Application by Port of Tilbury London Limited for an Order Granting Development Consent for a Proposed Port Terminal at the Former Tilbury Power Station ('Tilbury2') Ref: TR030003

The Examining Authority's First Written Questions and requests for information (FWQs) Issued on 27th February 2018

Thurrock Council (TC) response

FIG. 10.1

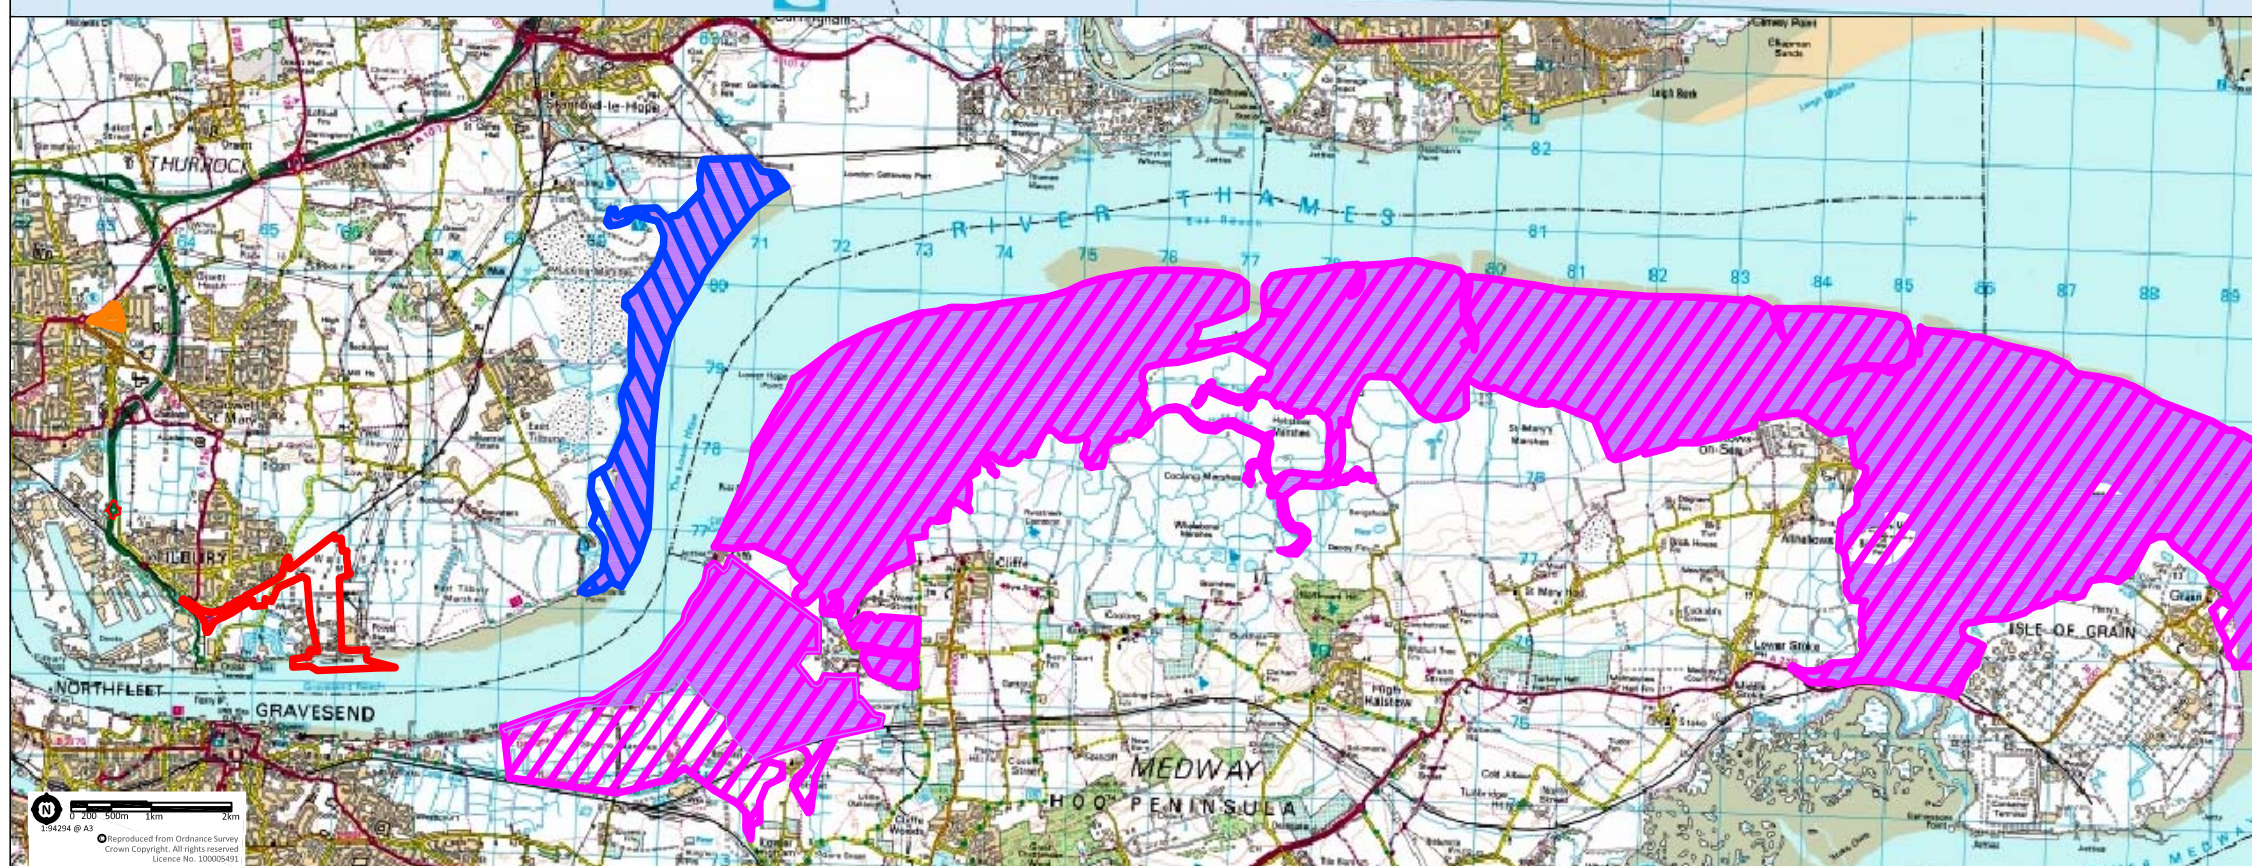
1.2.14	TC	<p>Local Wildlife Sites Please advise whether the site plans and details of the LoWSs that would be directly impacted by the Proposed Development, provided</p>	<p>The current citations and maps for the two existing Local Wildlife Sites are attached (Appendix 1.2.14a). These are still showing on the Council system. However the Council is not in a position to confirm whether the Tilbury Centre LWS</p>

<p>by the Applicant [APP-047] remain extant, or whether any boundary changes or grounds for designation have changed. If there have been changes, please provide up to date versions of the relevant documents.</p>	<p>is still present due to the ongoing demolition works in the surrounding area.</p> <p>The draft citation for the proposed new Local Wildlife Site area is also attached (Appendix 1.2.14b). This has been shared with the Tilbury 2 ecologists previously and is shown in their reports.</p>
